OXFORDSHIRE COUNTY COUNCIL'S RESPONSE TO CONSULTATION ON THE FOLLOWING DEVELOPMENT PROPOSAL

Application no: 24/01372/F

Proposal: Employment development (Use Classes E(g)i and/or E(g)ii and/or E(g)iii), and associated infrastructure, access (including diverted public right of way), parking, and landscaping

Location: Bicester Gateway Business Park, Wendlebury Road, Chesterton

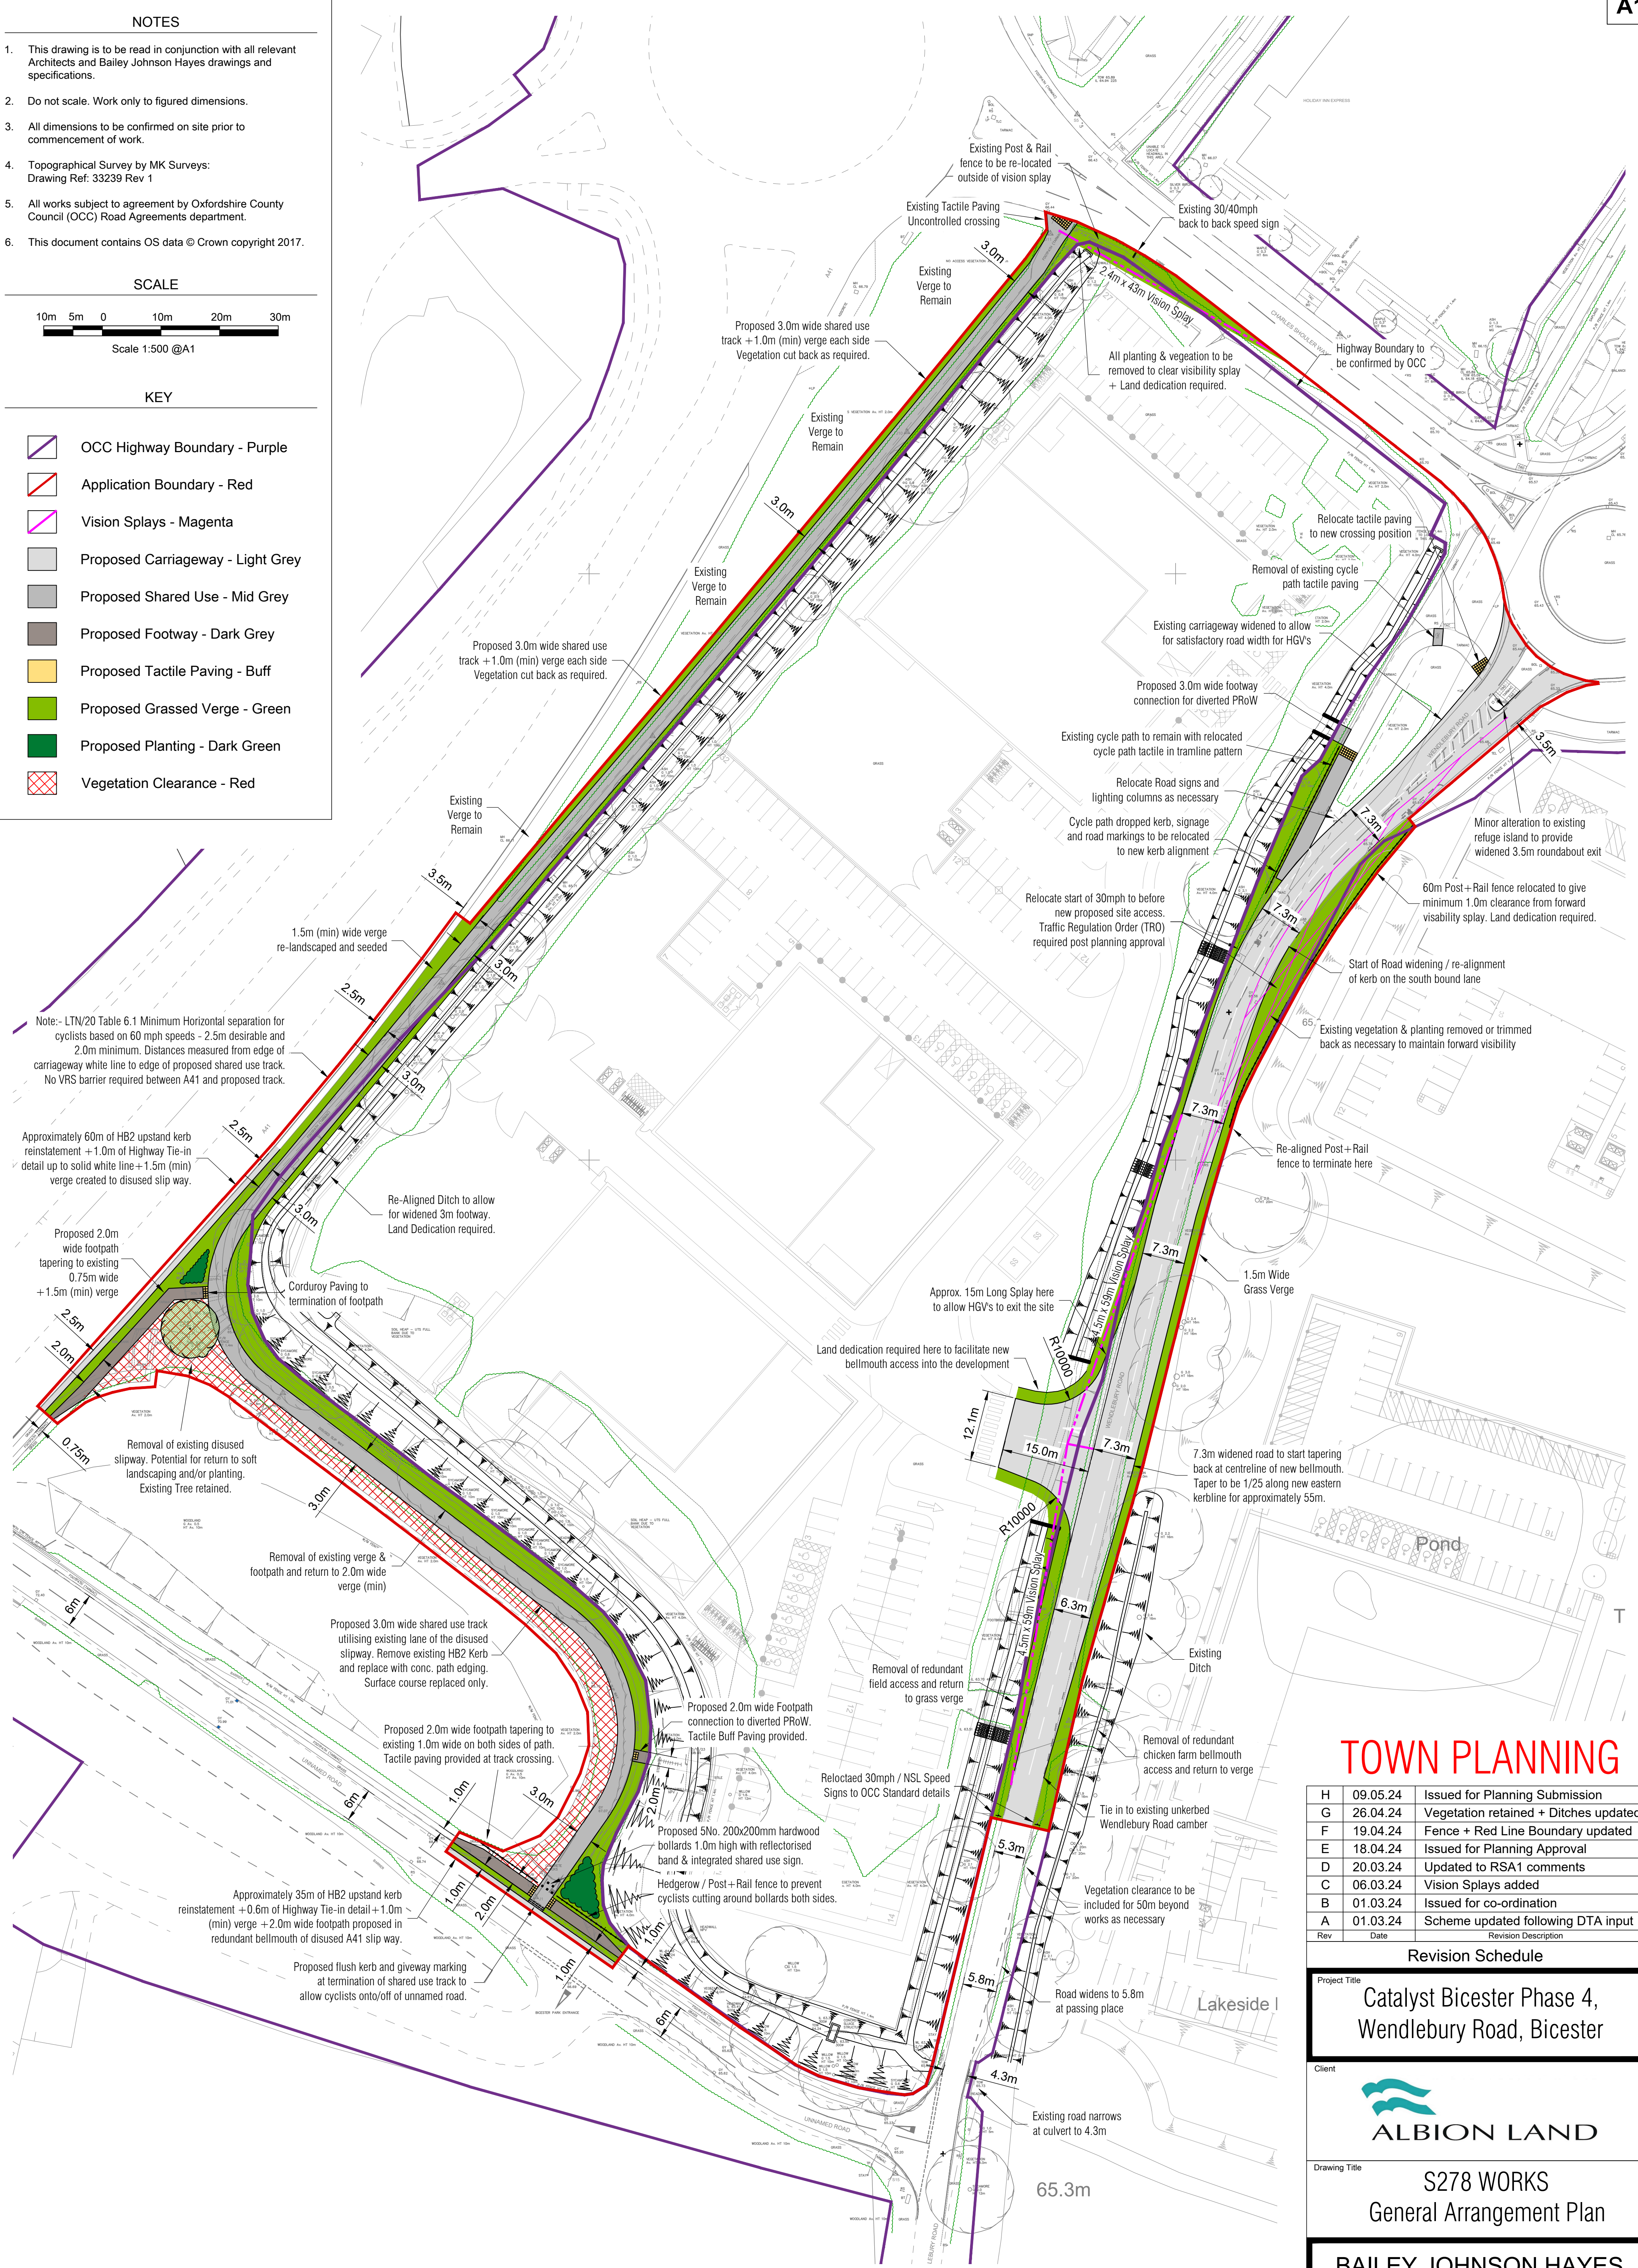
Within the site a section of permissive path is proposed to link the diverted Public Right of Way with the shared use facility at the junction of Wendlebury Road and Charles Shouler

Way. This is necessary in order to prevent pedestrians having to walk along the carriageway, which would be subject to increased HGV usage as a result of the development. However, this provision would not be of great use for northbound cyclists already on the Wendlebury Road who will have to navigate the new site access and conflicting traffic movements.

As listed on the drawing the Wendlebury Road is a Cycle Route which cyclists will continue to use. Therefore the County requests that the developer extends the footway/cycleway across the frontage to south of the access. The cycleway across the new access should be a set-back design in line with LTN 1/20. The cyclists would then be able to leave the carriageway in the location below. **Reason for objection**

An additional cycle connection between the site and the improved cycle facility alongside the A41 to the north of the site should be provided to improve permeability, convenience and encourage use of active travel. **Reason for objection**
